12 August 2010

**REQUEST FOR ADDITIONAL INFORMATION
THOMAS STREET CAR PARK MP09_0066**

We write to you on behalf of the applicant, Welles Thomas, in relation to your email dated 23 July 2010 requesting additional information in relation to the proposed redevelopment of the Thomas Street Carpark, Chatswood. Our response is provided below, for ease of reference I have included your original comments (*italics*) with our response under each comment.

**1** BASEMENT 5 PLAN  
1:200

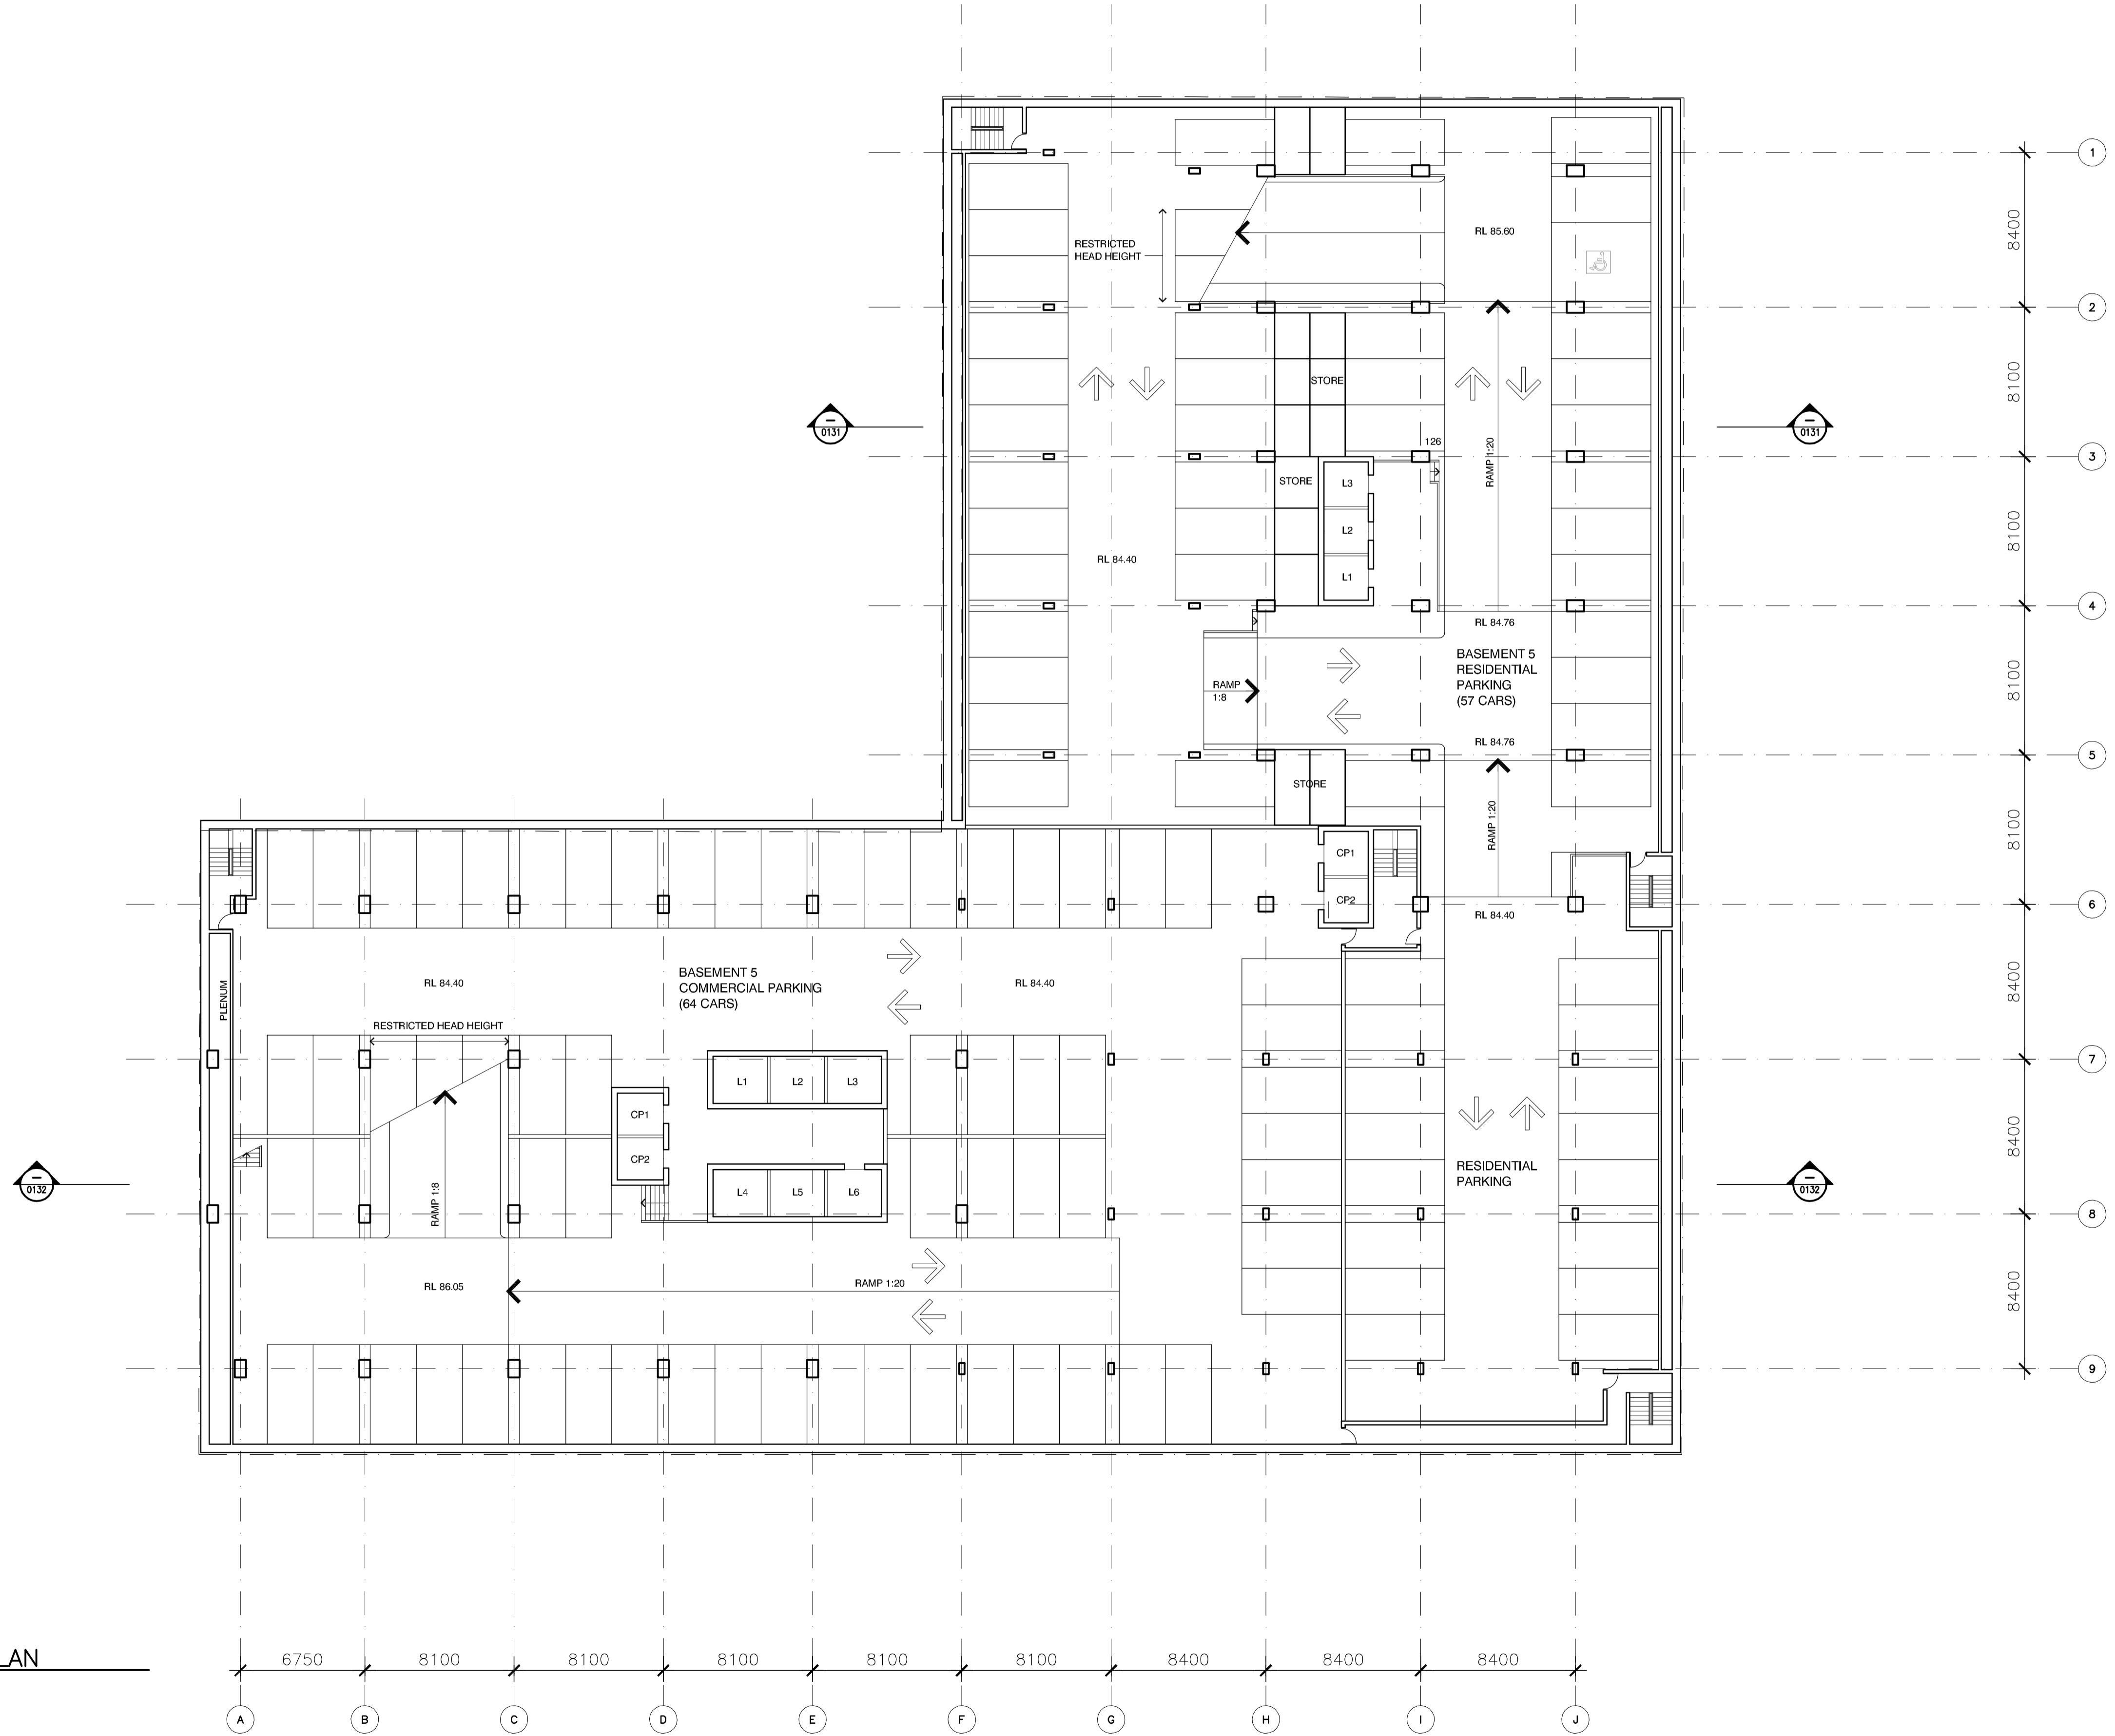
"The Department requests proper architectural plans drawn at an appropriate scale be submitted for any proposed modifications to the building layout."

Modifications to the building layout will occur below ground and will not have any impact on the operation or amenity of neighbouring property. It is requested that the Department of Planning impose a condition of consent requiring the submission of detailed architectural plans to the Department of Planning prior to the issue of a Construction Certificate.

**SWEPT PATH ANALYSIS  
OF A 6.4m RIGID  
VEHICLE ENTERING THE SITE**

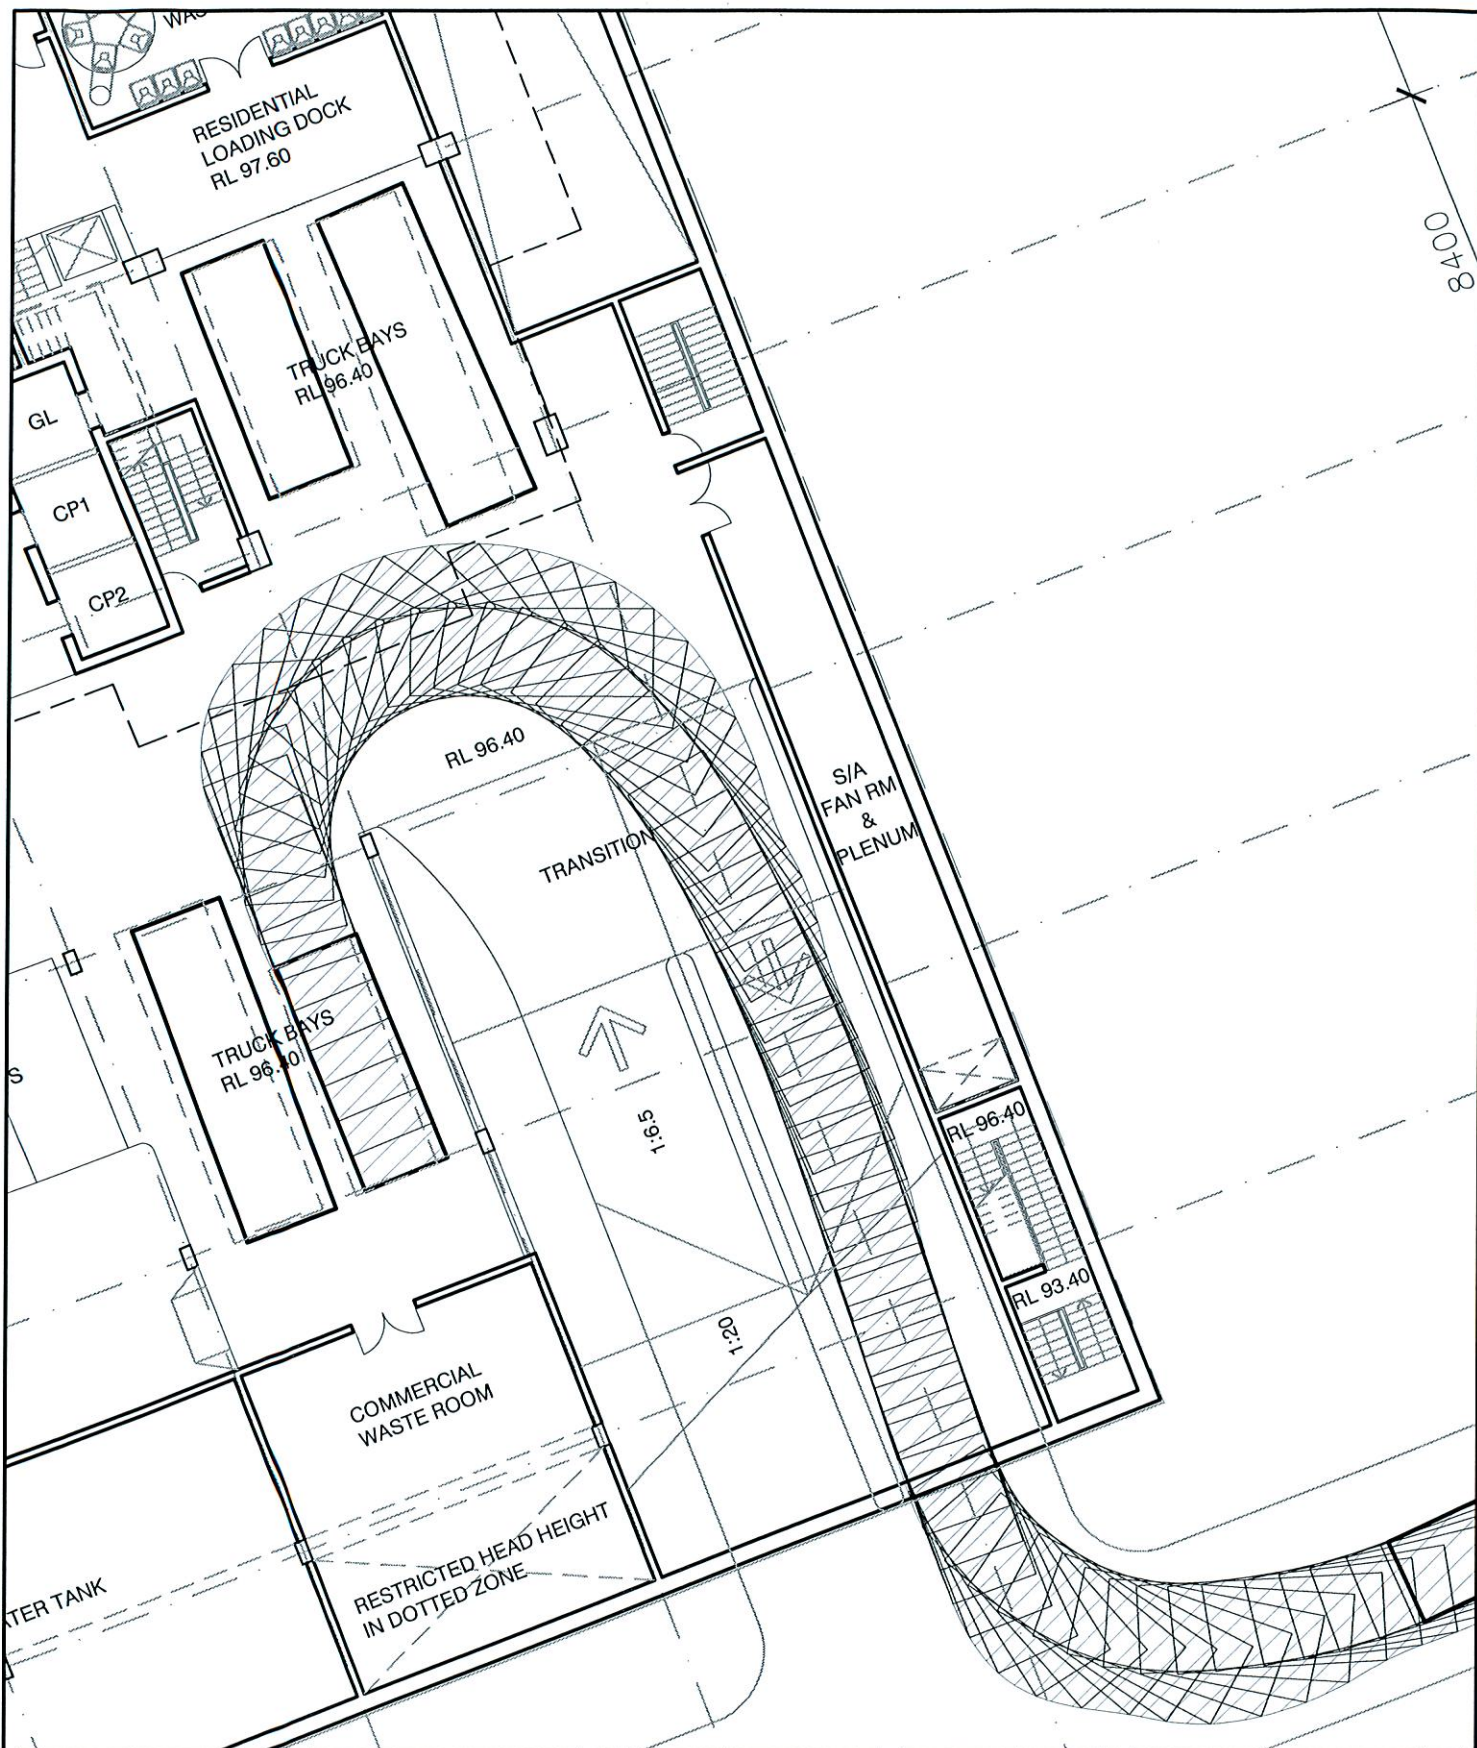
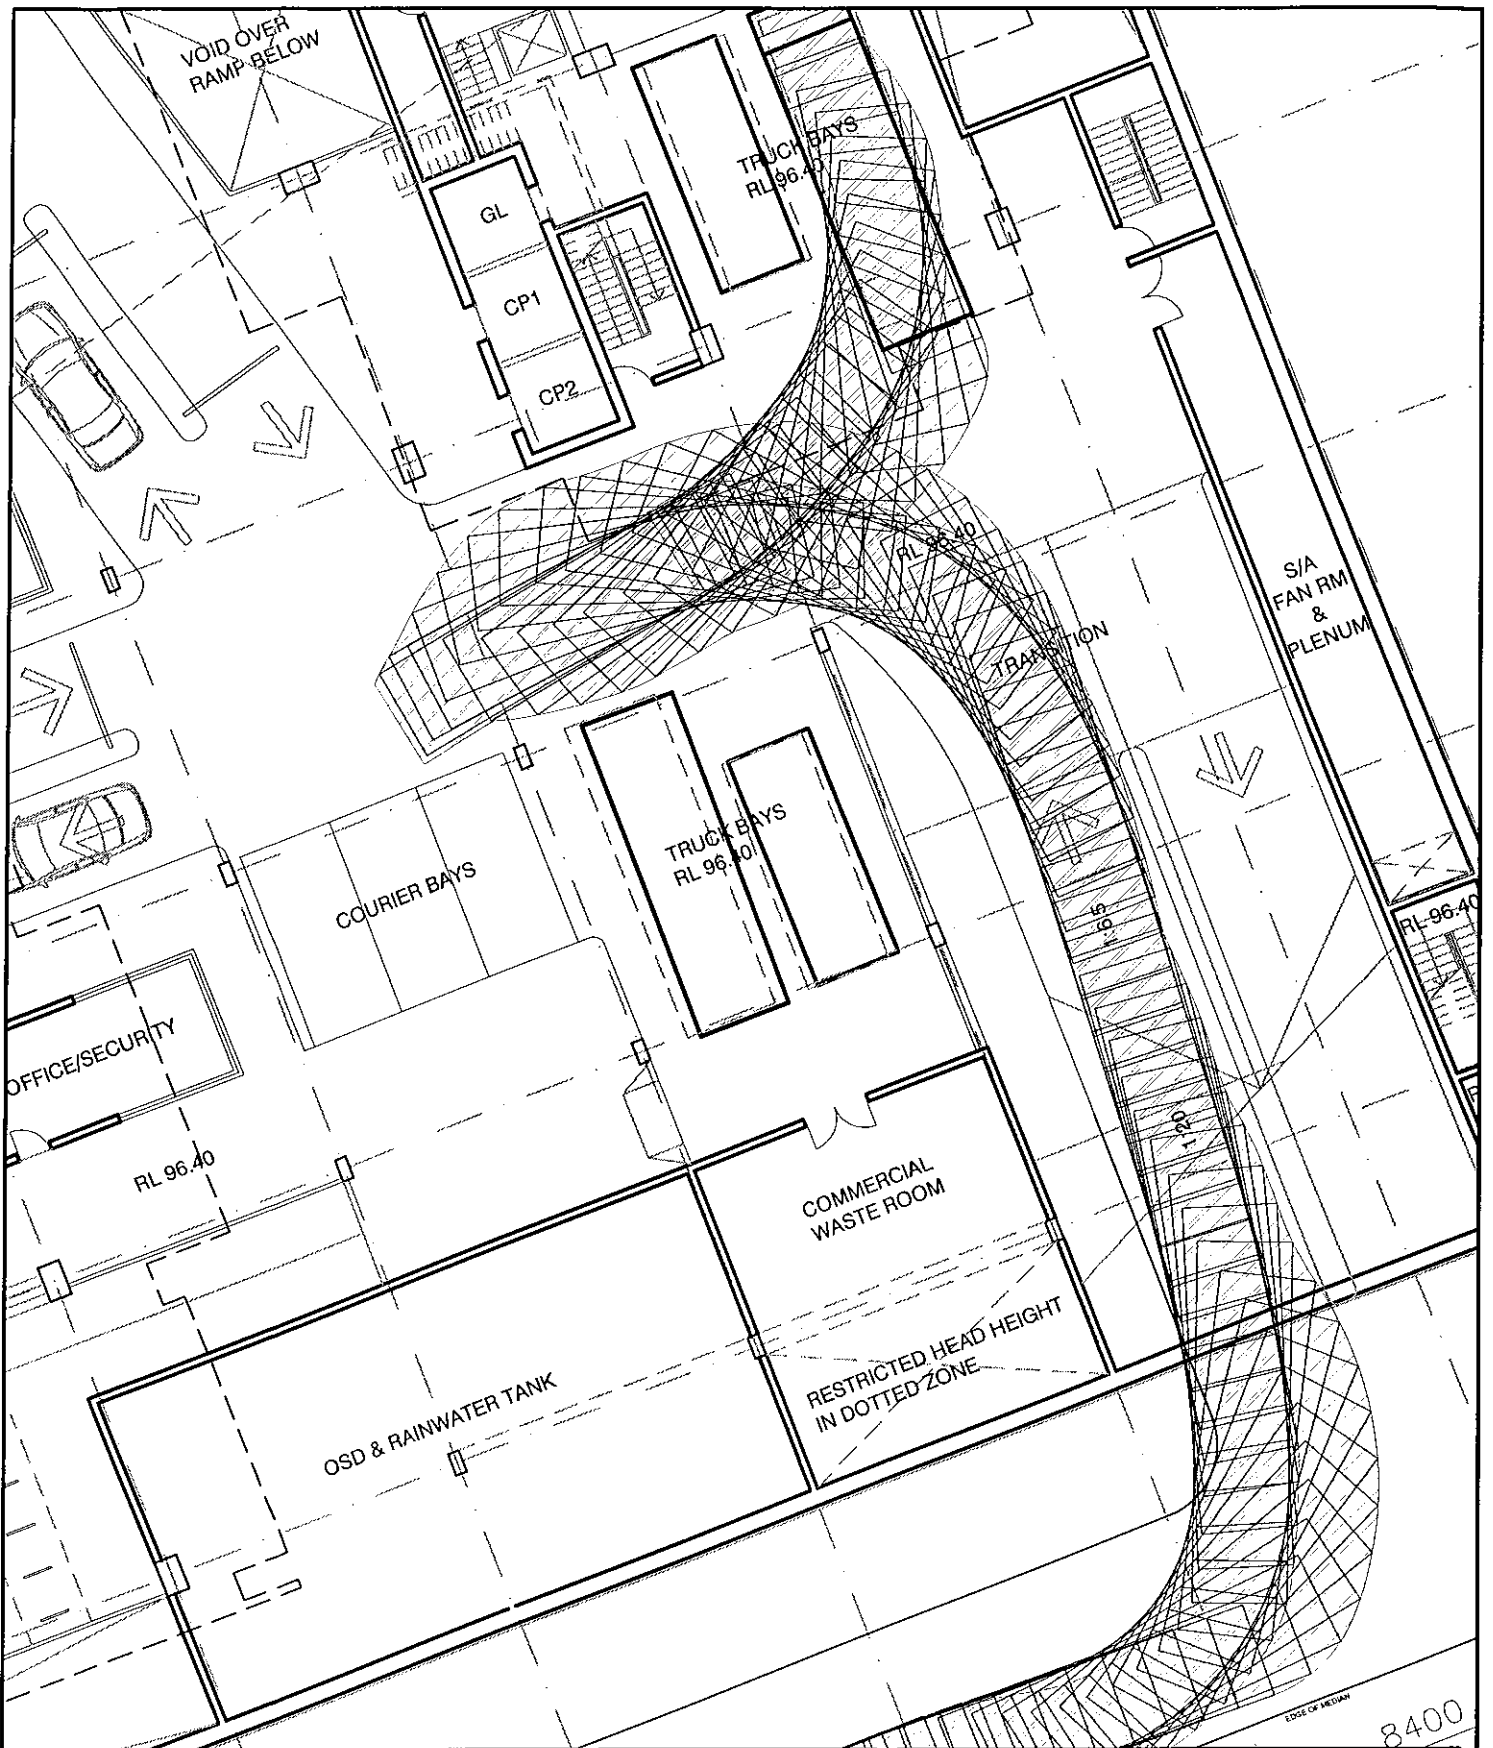
"Further information is required in support of the reconfiguration of the basement level. A swept path analysis for garbage collection vehicles is to be provided that demonstrates the ability to manoeuvre within the allocated turning areas and to safely enter and exit the site at Albert Avenue with the median strip in place on Albert Avenue. Further information demonstrating the management of potential traffic conflicts for vehicles using the exit ramp and entering the Right-Of-Way on Thomas Street is also required."

A swept path analysis of the entrance and exit ramps of the proposed development and the basement loading areas is also provided at **Attachment D**.
